Ribble Valley Borough Council
Housing & Development Control

Application no: **3/2021/0618**

Address: **Albion House Kirkmoor Road Clitheroe BB7 2DU**

Proposal: **Provision of an off road parking space for Albion House by changing the configuration of the garden (altering the position of the existing wall).**

3/2021/0618

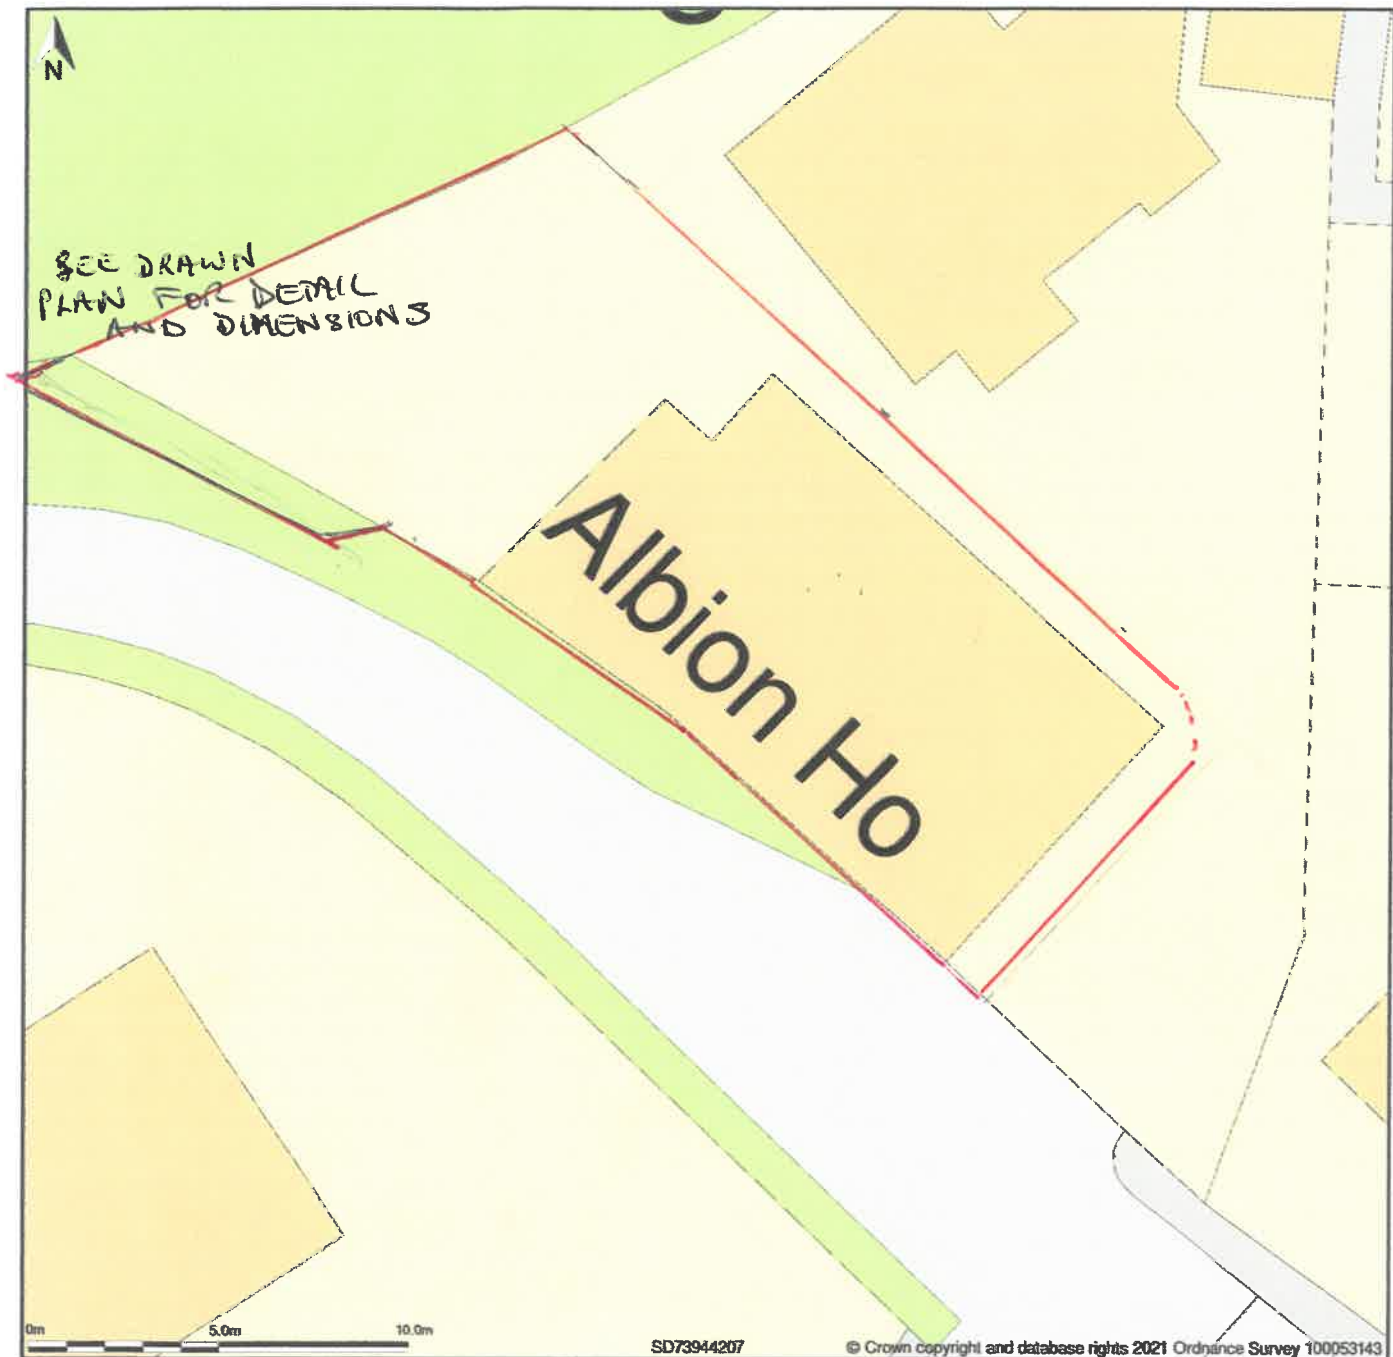
The LHA have reviewed the drawing titled "Proposed Plan" and understands that the access arrangements complies with the LHAs guidance.

Usually, the LHA would normally require the gate to be set back a distance of 5m from the public highway and the maximum vehicular visibility splays to be shown on a scaled drawing to support the creation of a new access.

However, due to the site being accessed off a private, unadopted road the LHA will accept the gate not being setback the required distance from the highway and will not request vehicular visibility splays to be shown on a scaled drawing. Therefore, the LHA have no objection to the proposal.
